H16/0835/01

Description: Proposed office block to
replace existing

Location: **Kellet Gate**
Spalding
Lincs

Planning Application Proposed Office Block, Kellet Gate Spalding Lincs

DRG No. 1823 / GA3

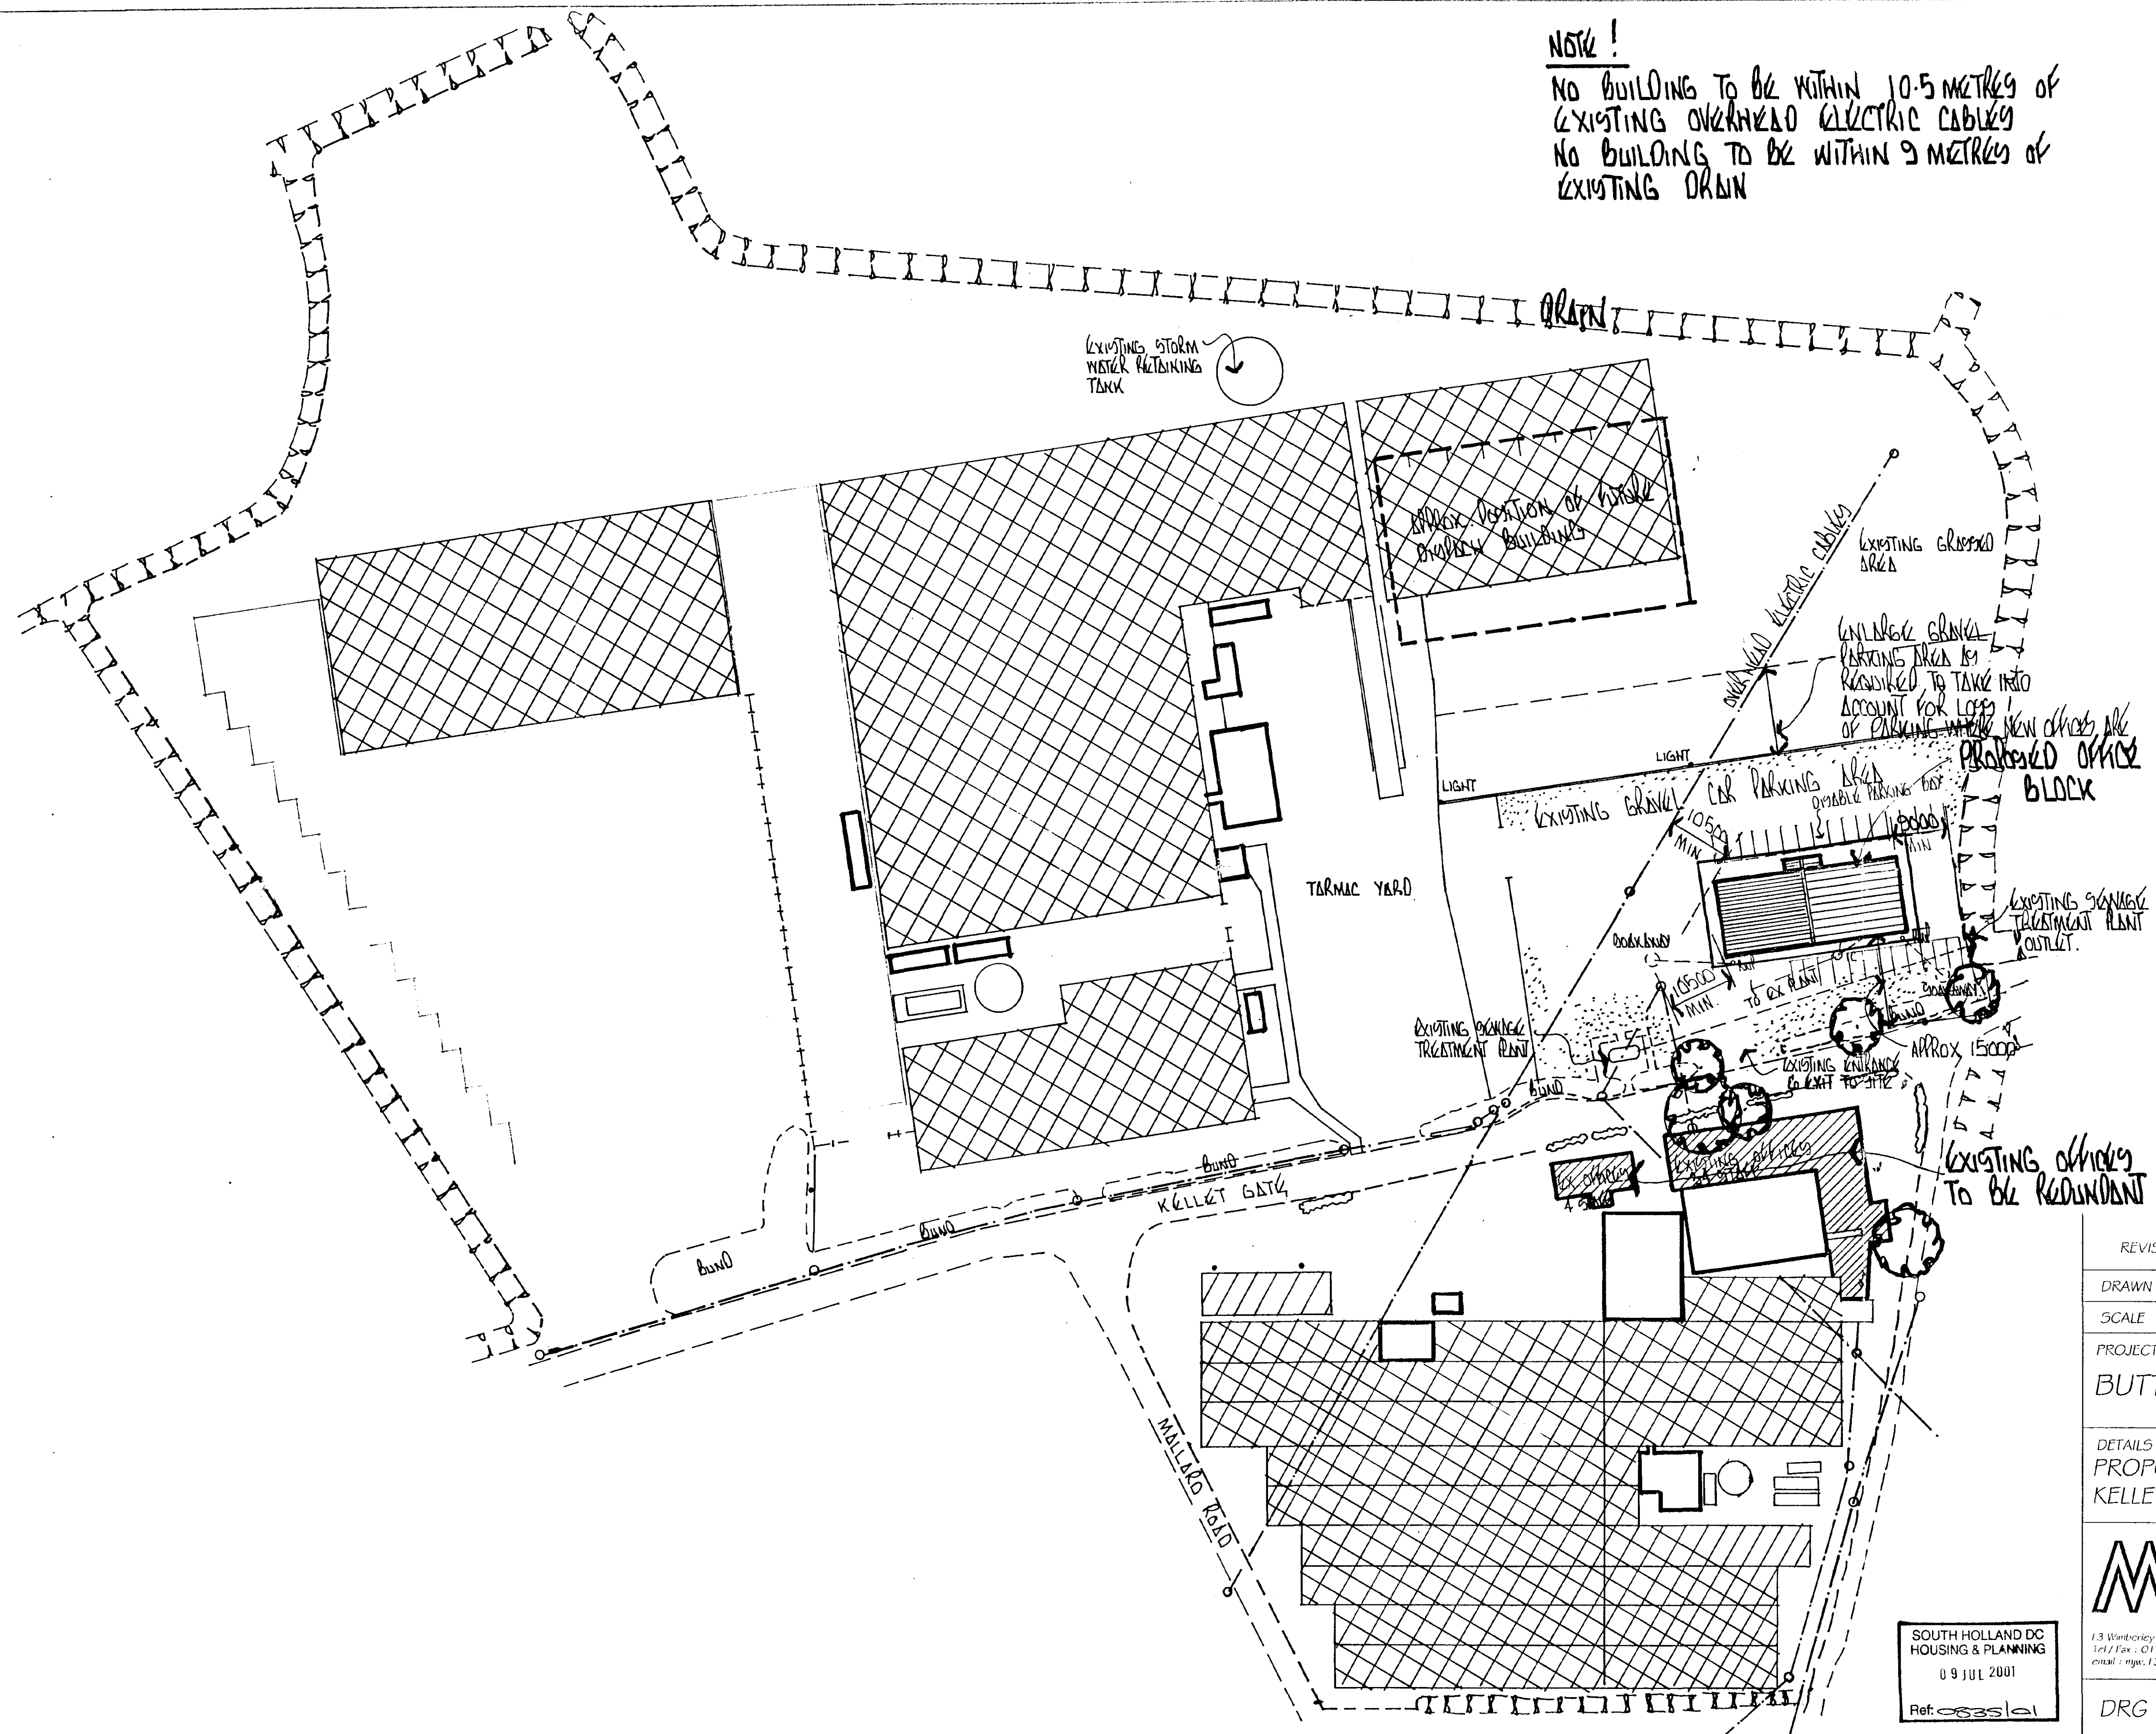
- The proposed building is in the middle of what is currently a large car park. What provision is to be made for the parking of those cars which would be displaced by the building?
- The Area Highways Manager is concerned about the damage being caused to the fabric of Kellet Gate by the increased traffic use which is a consequence of the expansion of business along the road. What will be the nett effect of the construction of the new office in terms of traffic generation?

- The existing gravel car parking area will be extended to cater for the loss of car parking space due to the proposed new office block (see notes on drawing 1823/GA3).
- The proposed new office block is to replace the existing offices, which will become redundant and used for storage purposes only. All staff will be transferred across the road (Kellet Gate) to the new office block and therefore no additional traffic will be generated.
- Pedestrian safety will be greatly improved by this development as all office personnel will no longer have to cross Kellet Gate to gain access to the vehicle parking area.
